96 BILL LEATHEM DRIVE CHELLO Commercial Development

Design Brief

21 March 2024

**Subject: Phase 3 Pre-Consultation: Review Feedback
Proposed Zoning By-law Amendment & Site Plan Control – 96 Bill
Leathem Drive**

SITE PLAN

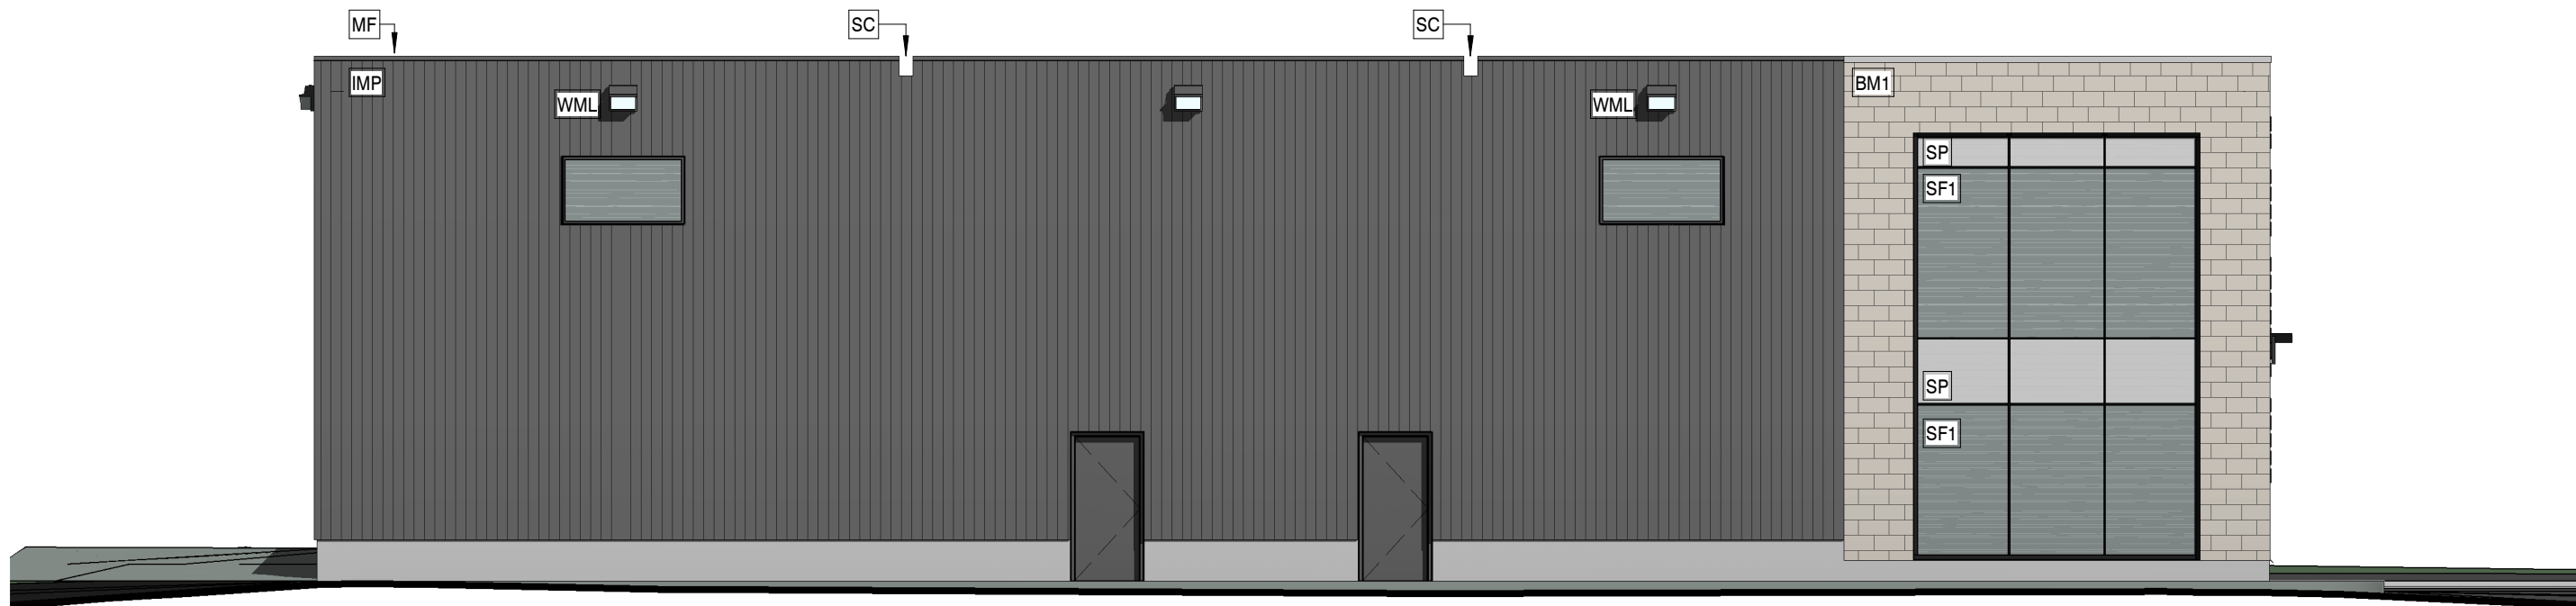
- A14. Revise the outdoor refuse collection area to comply with Section 110. The site plan needs to be zoning compliant prior to accepting the formal submission.
- A15. Update the Planning Rationale to include the required Urban Design Brief as per the Terms of Reference. Please also note that the submitted Planning Rationale references the City's old Official Plan (2003) and the Nepean South Secondary Plan, which are no longer in effect.
- A16. As per the Environmental Planning comments below, the site plan needs illustrate the limits of development (i.e. minimum required setback).

- B9. Consider removing the parallel parking spaces along the rear property line as this will provide additional opportunities for tree/shrub planting to screen the property from the adjacent multi-use pathway.

DESIGN	T.L.M.	PROJECT	96 BILL LEATHAM DRIVE PART OF LOT 18 CONCESSION 1 (RIDEAU FRONT) GEOGRAPHIC TOWNSHIP OF NEPEAN CITY OF OTTAWA		
CHECKED	T.L.M.	DRAWING TITLE	STORM DRAINAGE AREA PLAN		
DRAWN BY	P.M.	PROJECT No.	822-125	DATE	JUNE 2023
CHECKED	T.L.M.	DRAWING No.	D-1		
APPROVED	T.L.M.

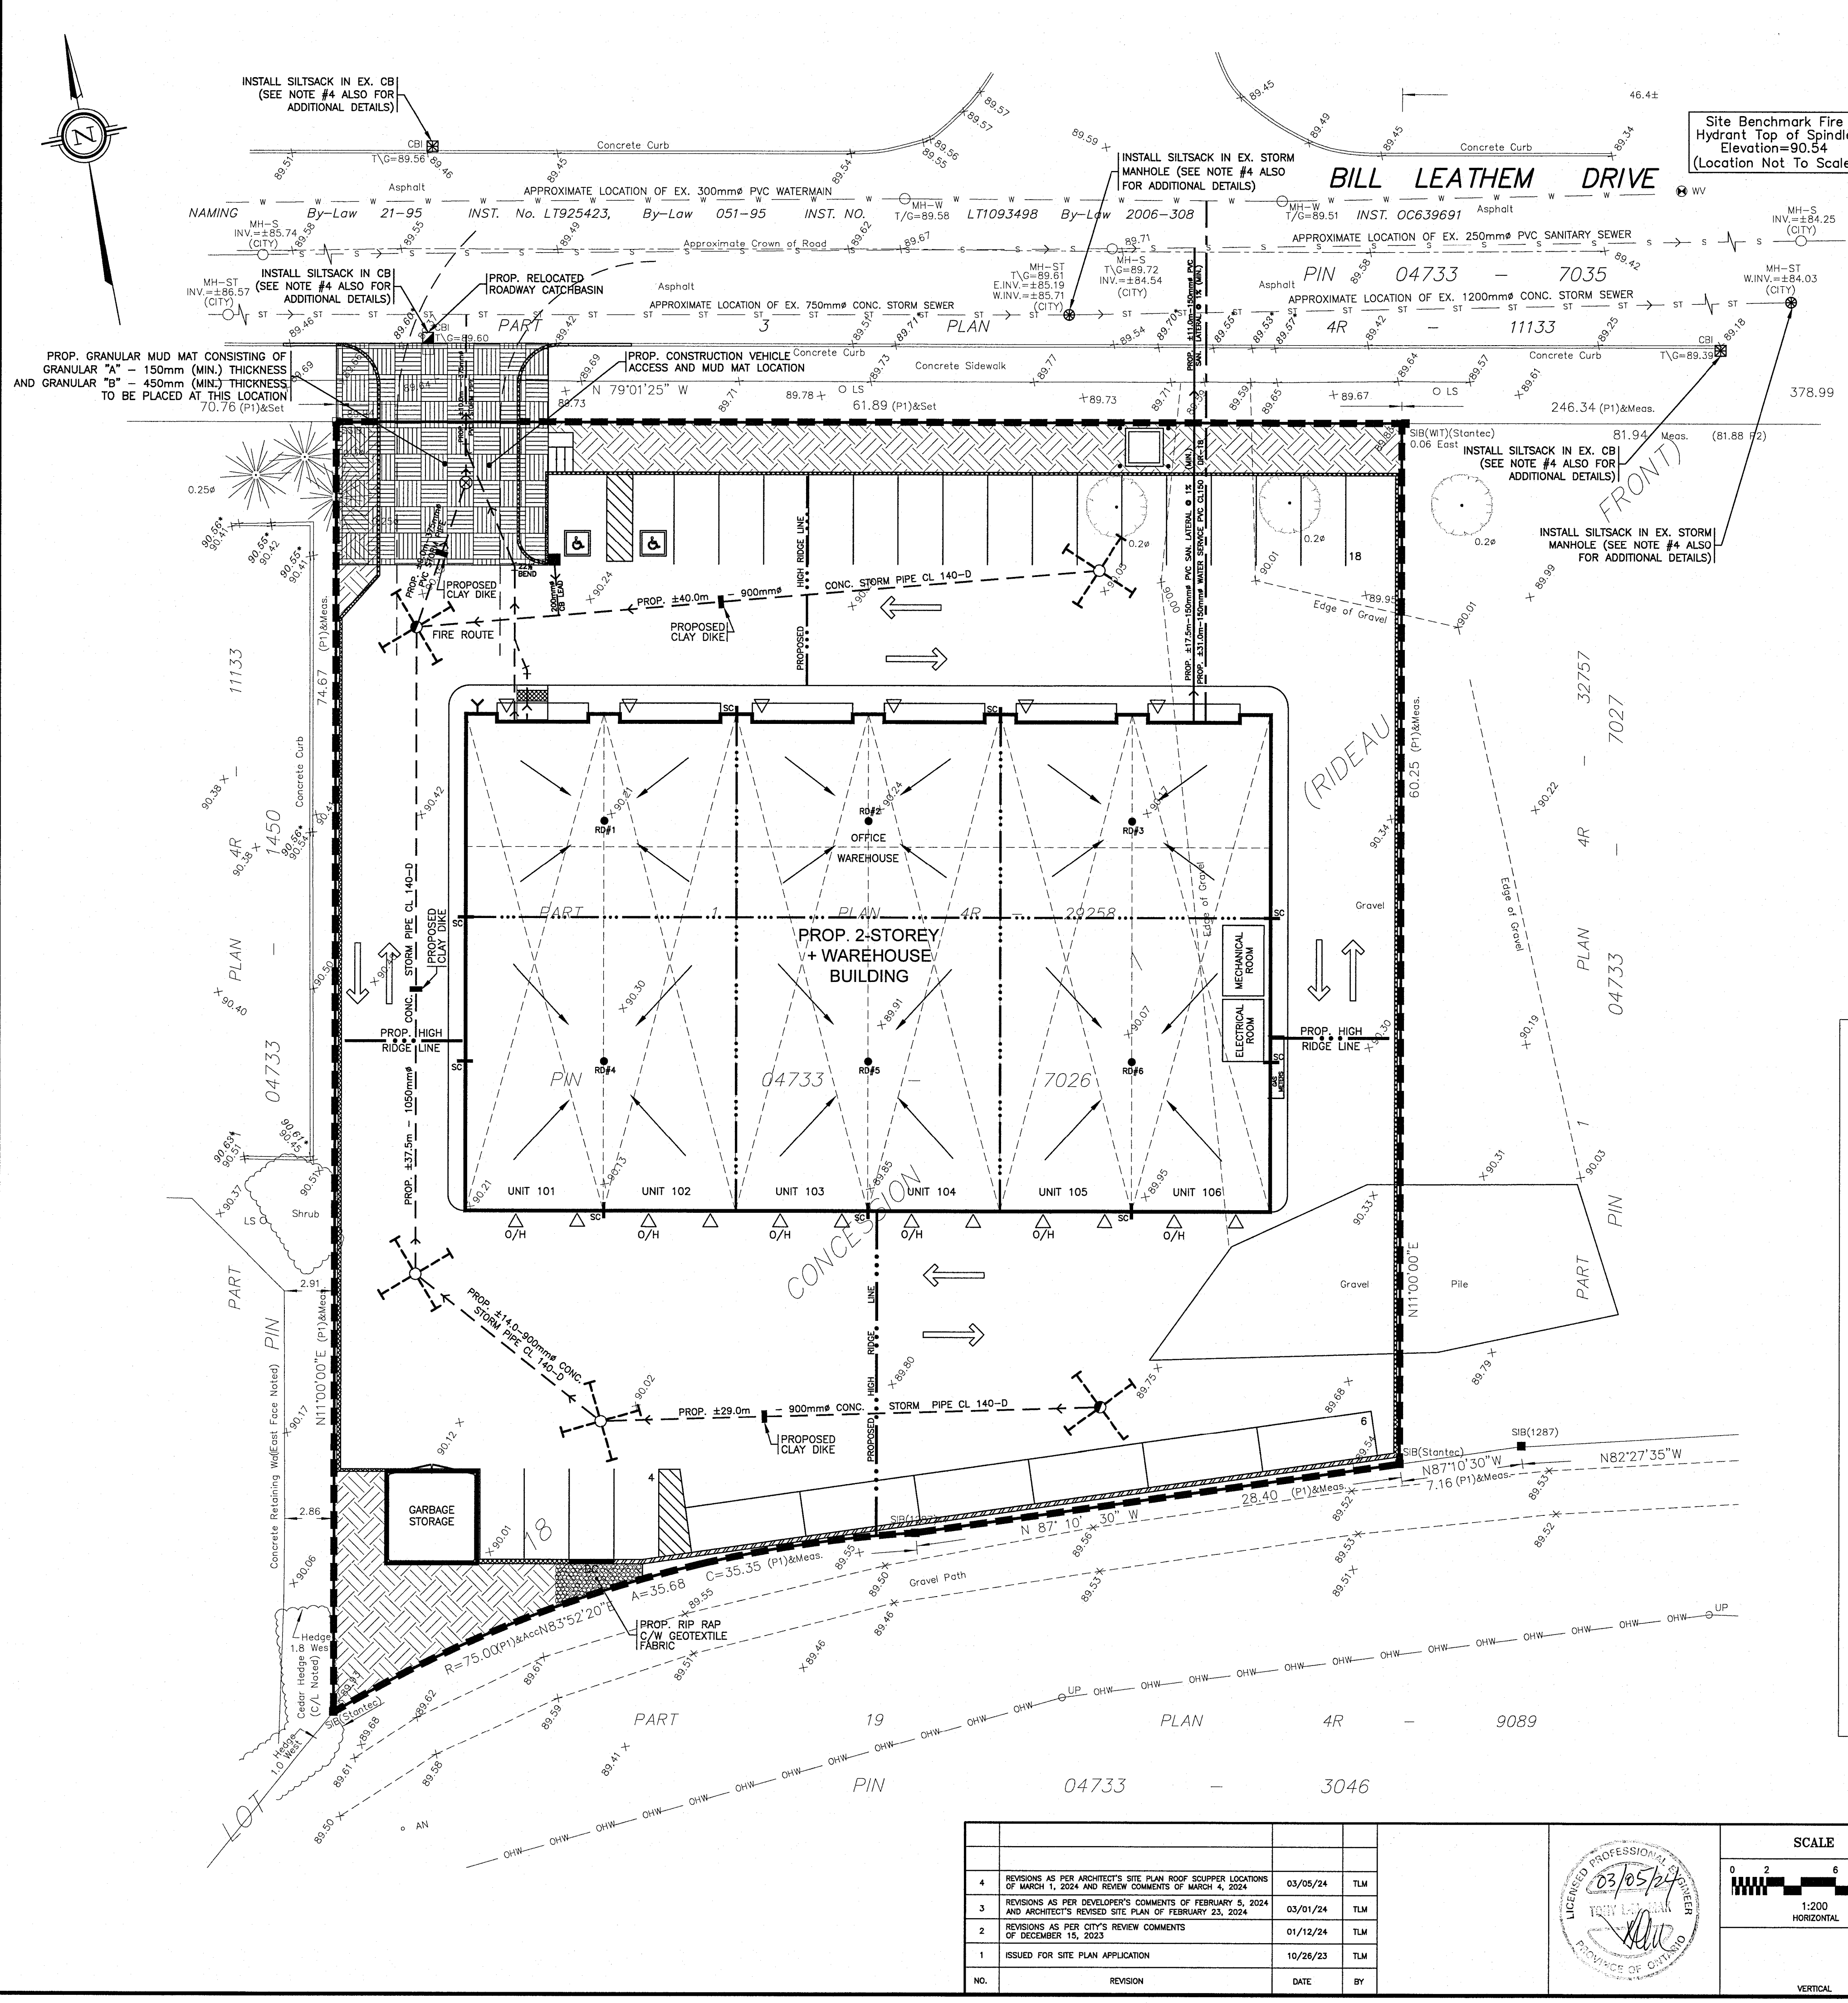
- B3. Drainage Area IDs should be unique (there are two Drainage Area 4s).
- B4. The drainage area for the parking surface should be divided into two (2) areas, one for each pipe-reach. See attached mark-up of the Storm Drainage Area Plan.

PROJECT No.	DATE	DRAWING No.
822-125	JUNE 2023	ESC-1

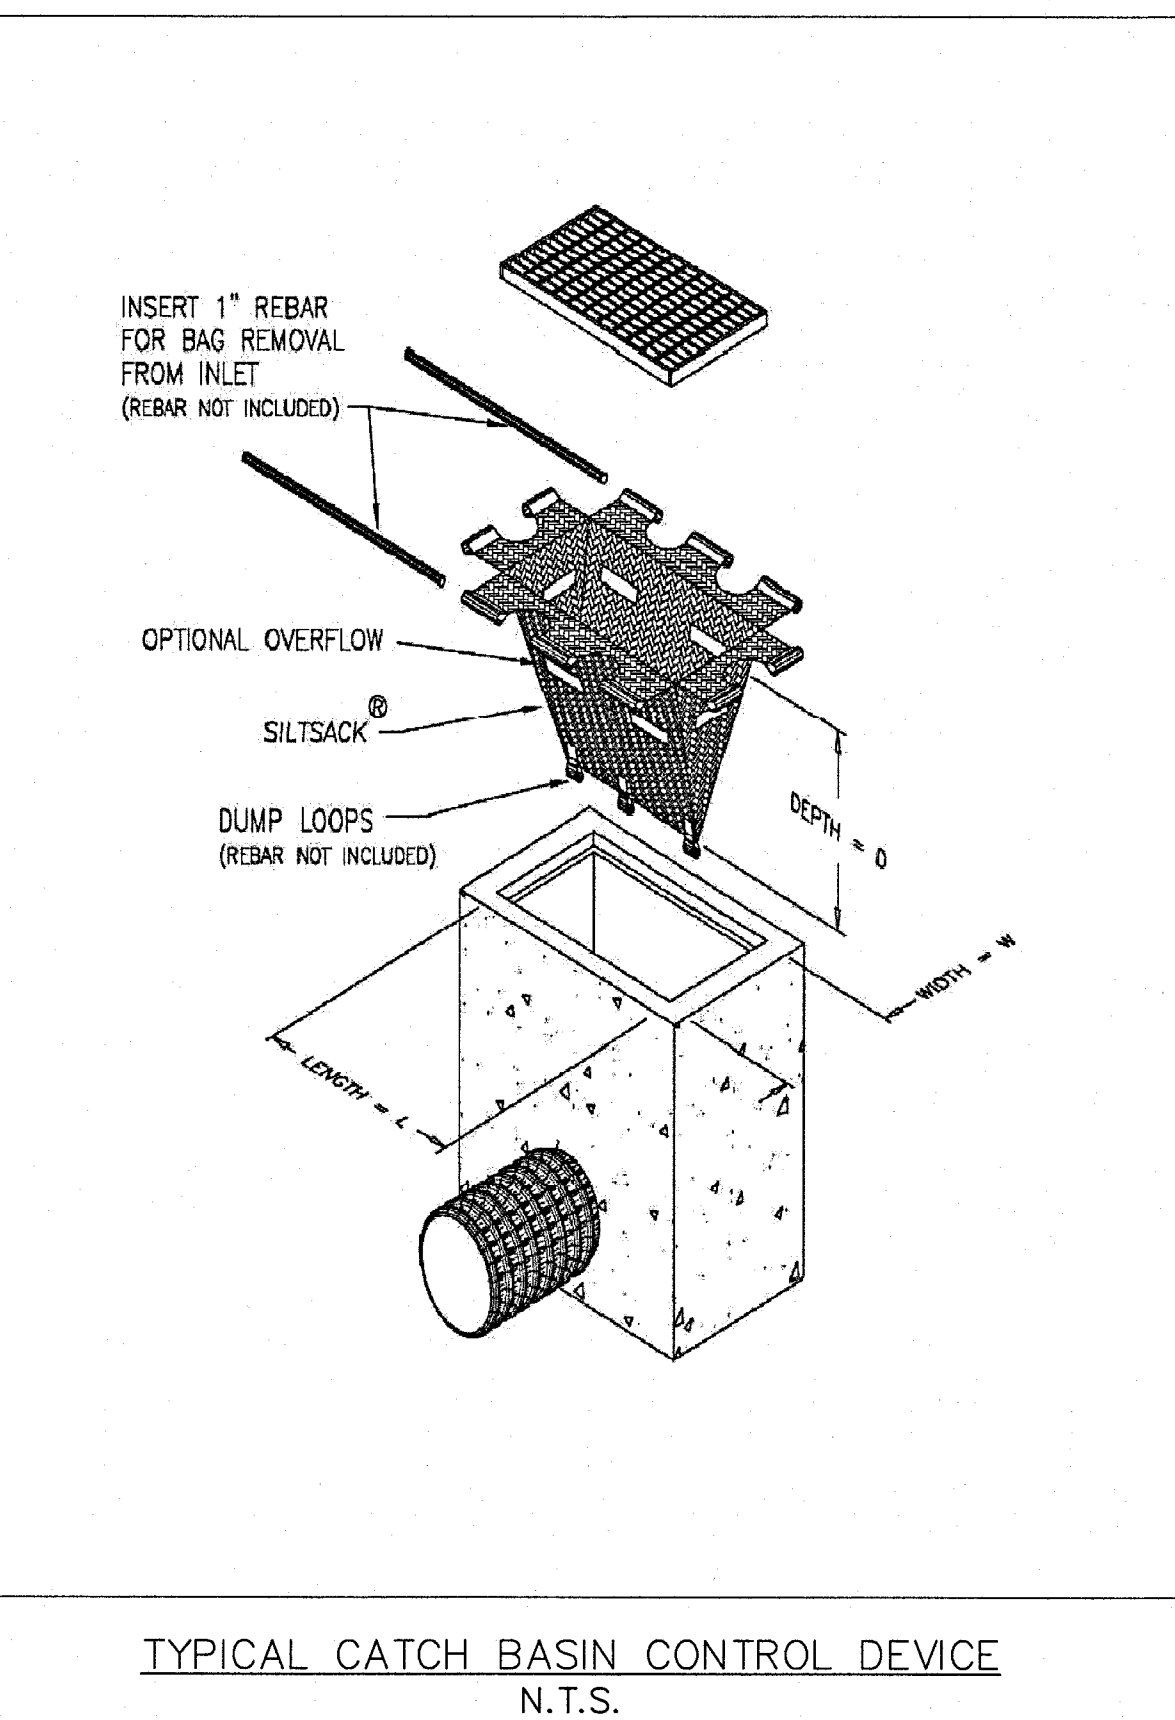
- A8. Silt sacs should be placed on all storm sewer maintenance hole and catch basin openings during construction. Update the legend as required.
- A9. A mud mat is required at the construction site access to protect the public realm.
